Consultation Response (Biodiversity)

Kirklees Council Conservation and Design Team, Biodiversity Officer

<i>Discharge of Conditions consultation response</i>		For office use
Date of response	22/08/2018	<i>Is this a response to an informal consultation request?</i> Yes ☐ No ☒
Location	Poplar Farm, Briestfield Road, Briestfield, WF12 0PA	
Application number	2018_92114	
Responding officer	Tom Stephenson

Drawing No. 1541_14_B

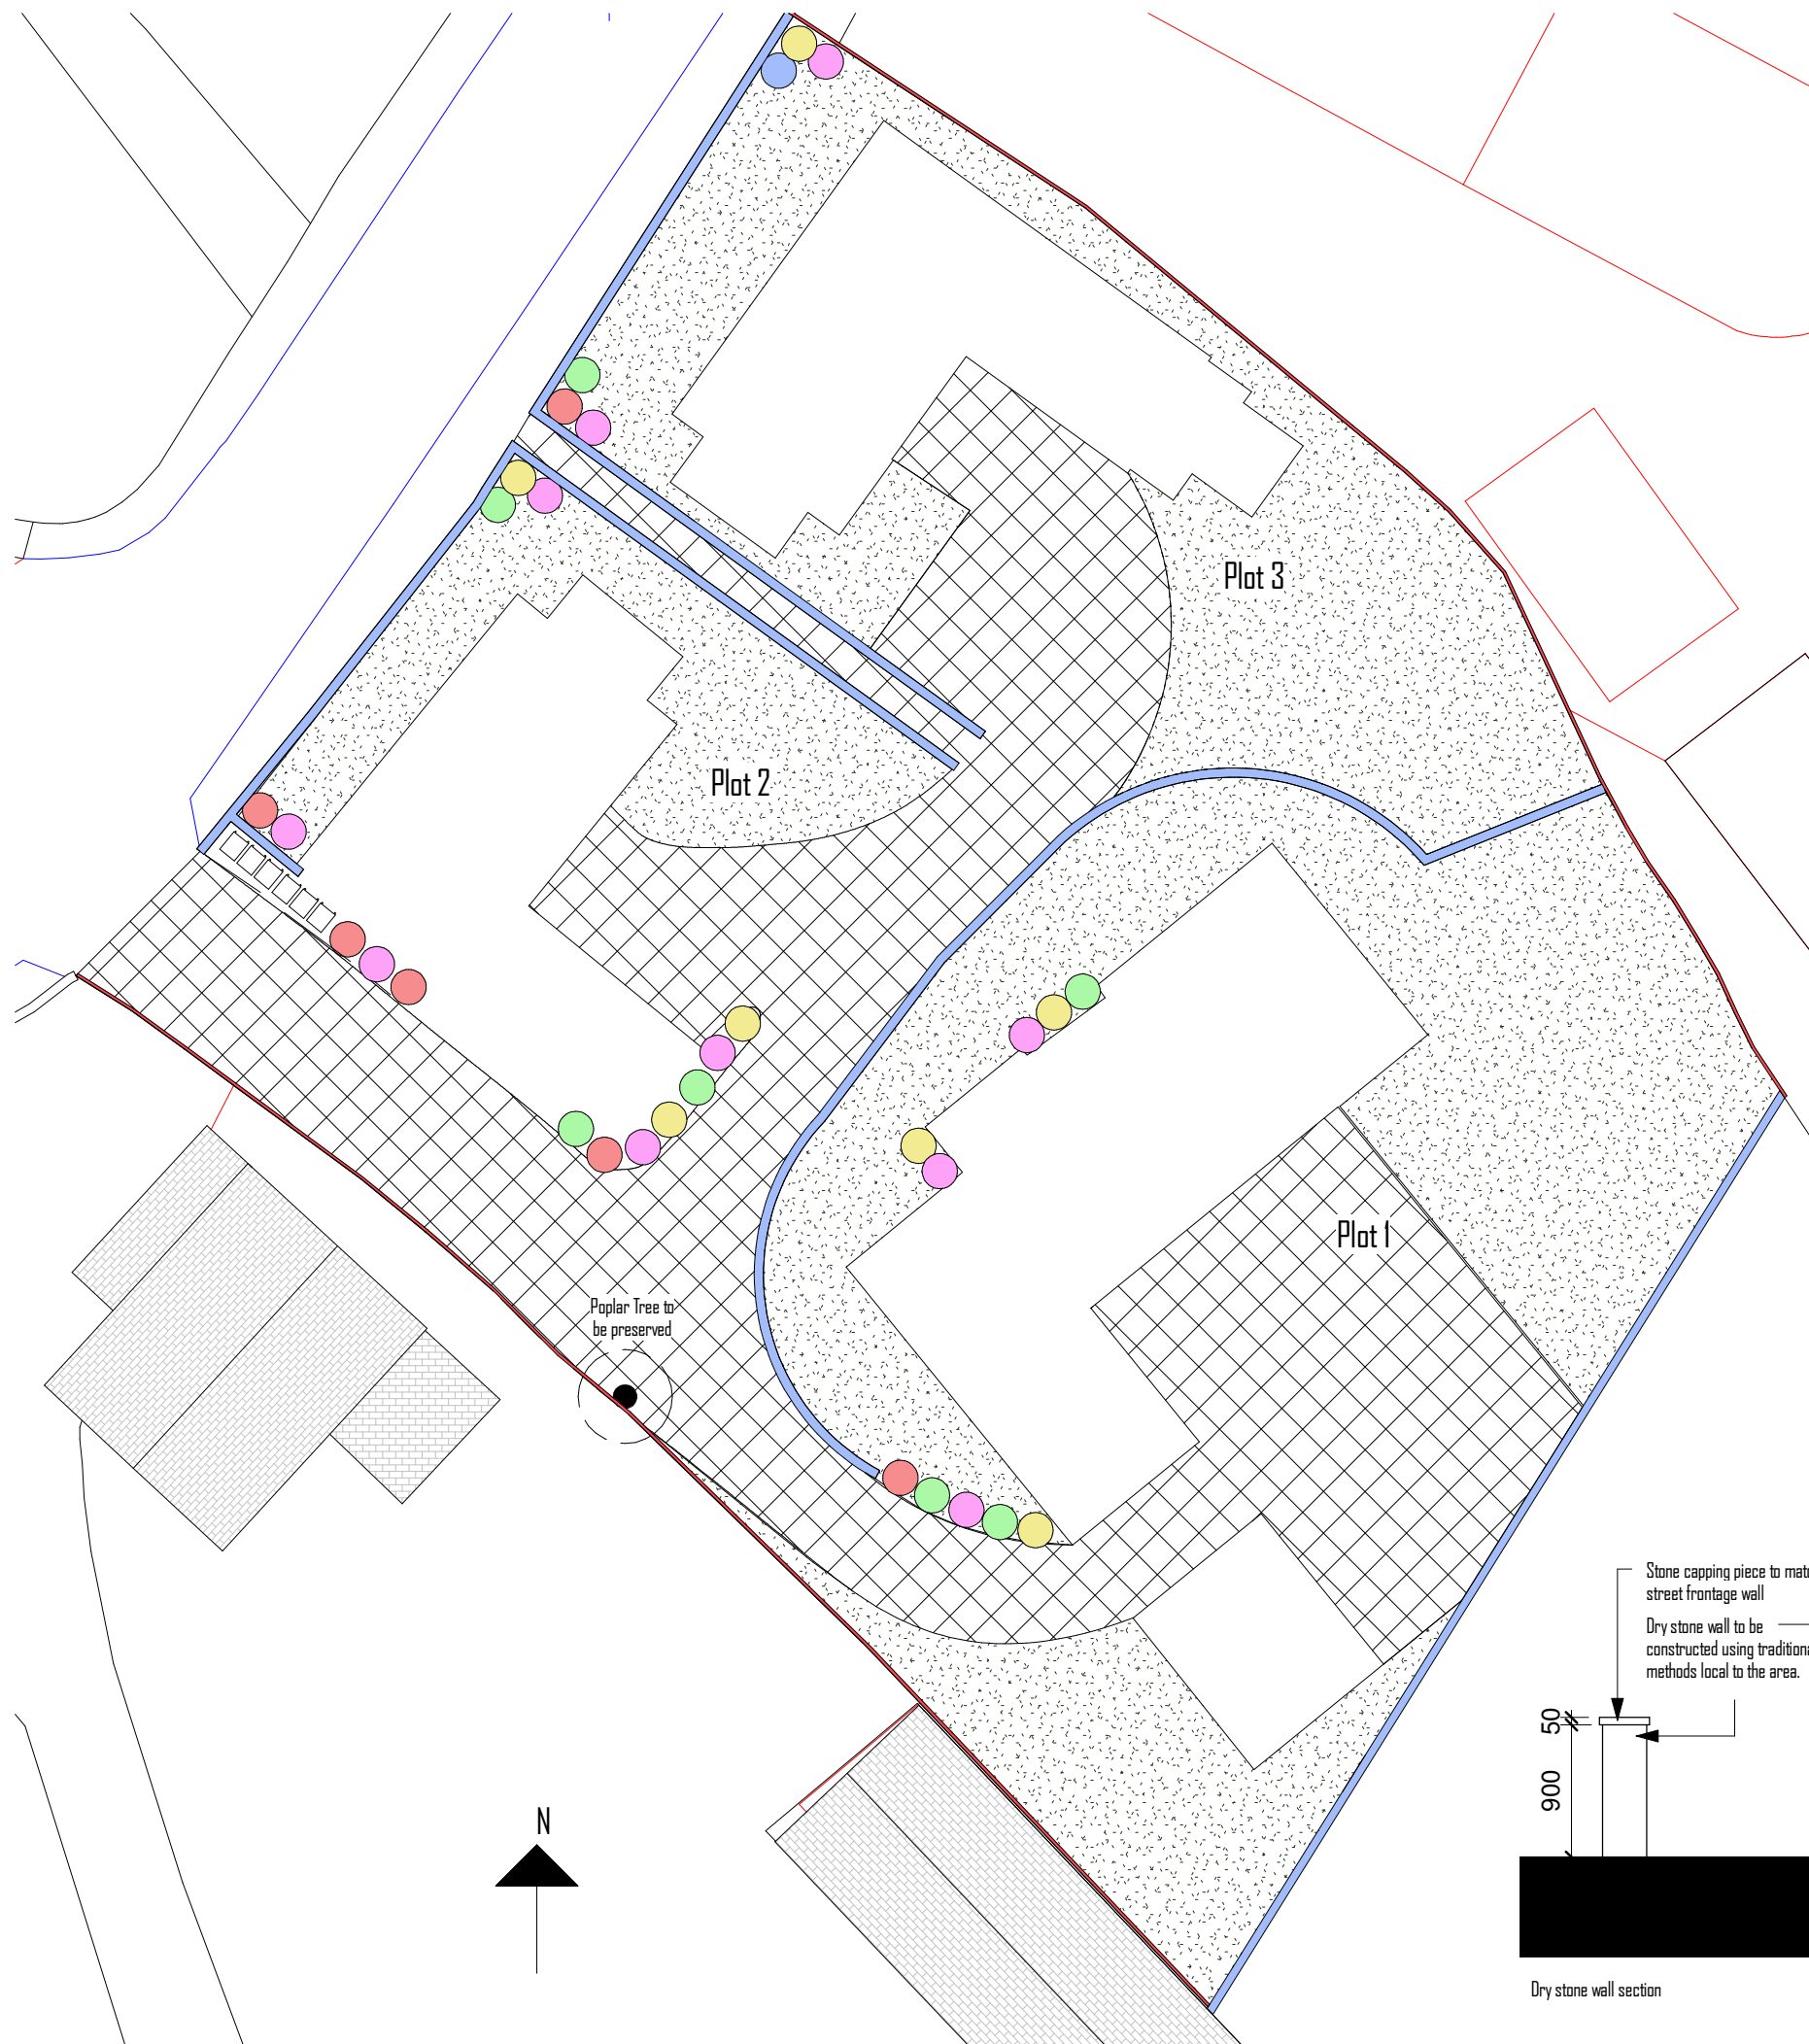
The submitted information makes no mention of ecological issues. The proposals are not sufficient to discharge the condition.
